Gatwick Northern Runway

TR020005

National Highways Comments on any Submissions Received by Deadline 7

August 2024

Title: **Traffic Regulation Plans Classification of Roads APFP Regulations 5(2)(o) Sheet 1A - Proposed Measures**

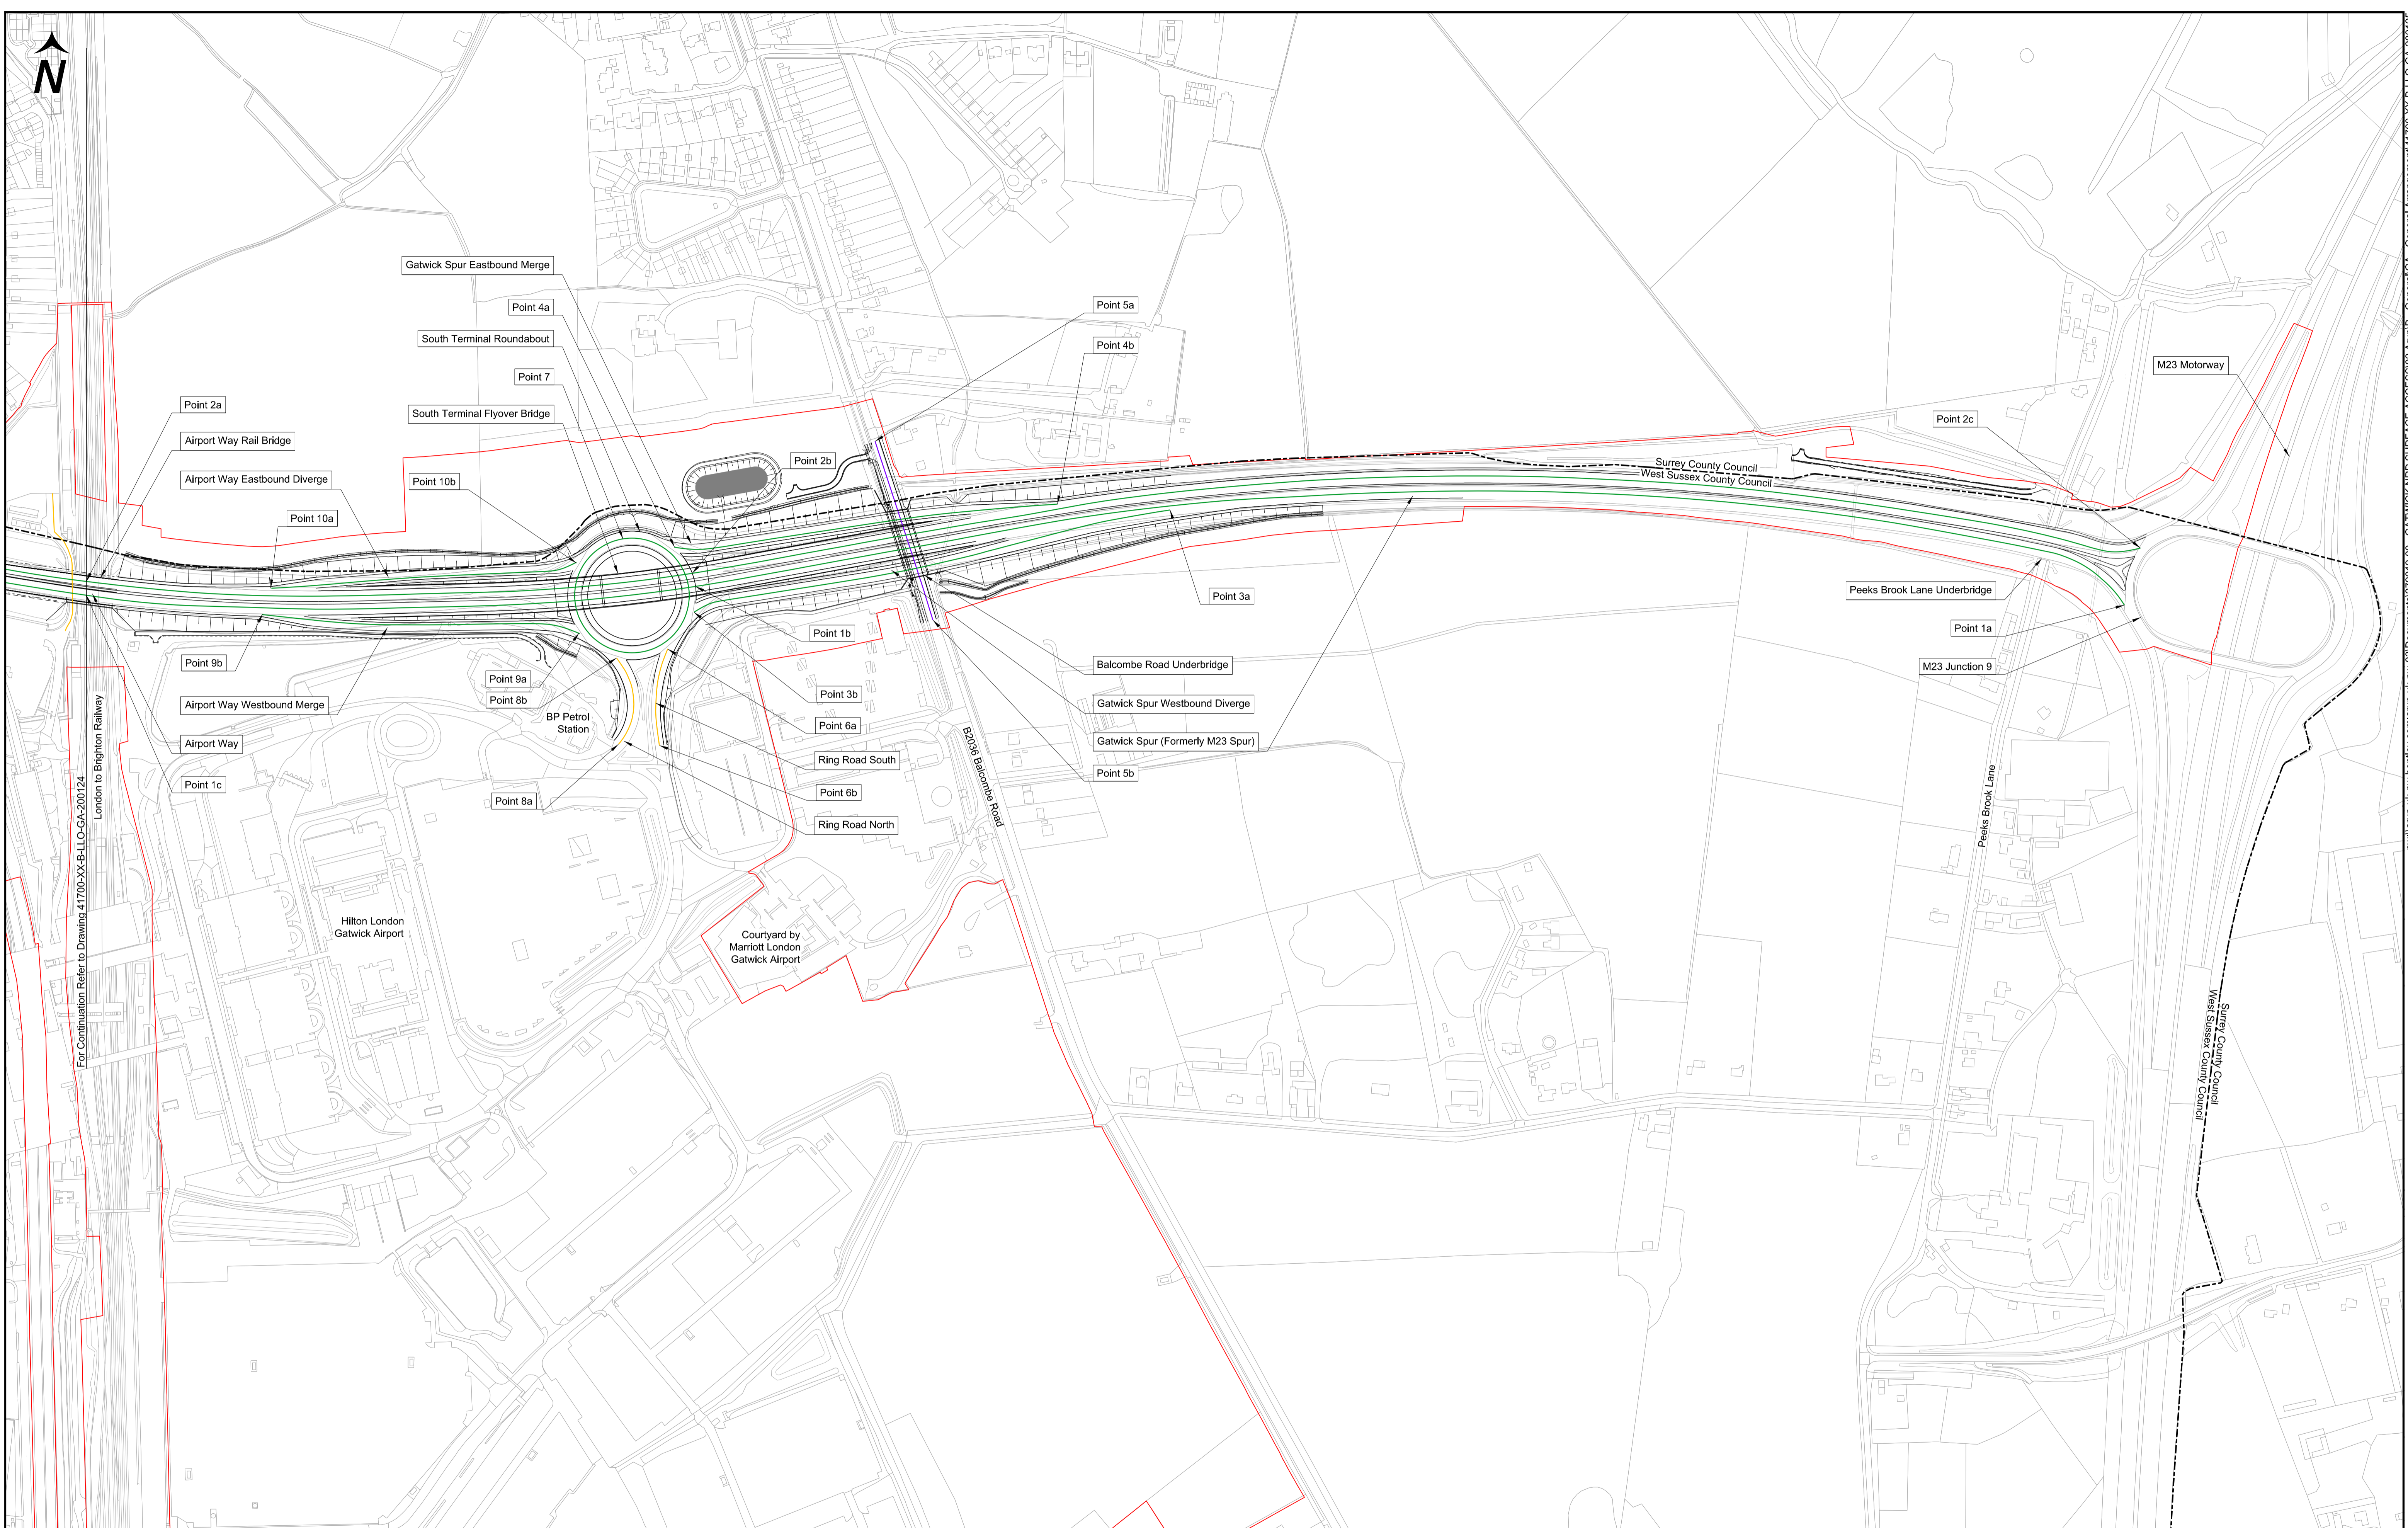
2.1 Draft Development Consent Order Version 9 (Tracked)			
Article 17 (3)-(4)	REP7-007	<p>(3) From the date on which Work No. 35 (South Terminal Junction improvements) is completed and open for traffic, the roundabout circulatory carriageway at junction 9 of the M23 is to cease to have the classification of motorway and will instead be classified as a trunk road with an A-road classification as if it had become so by virtue of an order under section 10(2) of the 1980 Act.</p> <p>(4) Any prohibitions in respect of the circulatory carriageway at junction 9 of the M23 or accesses onto that junction that are made pursuant to article 18(3)(b) or (e) can include prohibitions on its access and use by pedestrians and other forms of non-motorised users as well as vehicles</p>	National Highways can confirm that this wording is agreed with the Applicant and is necessary to ensure that the road classifications are updated following completion of Work No. 35.
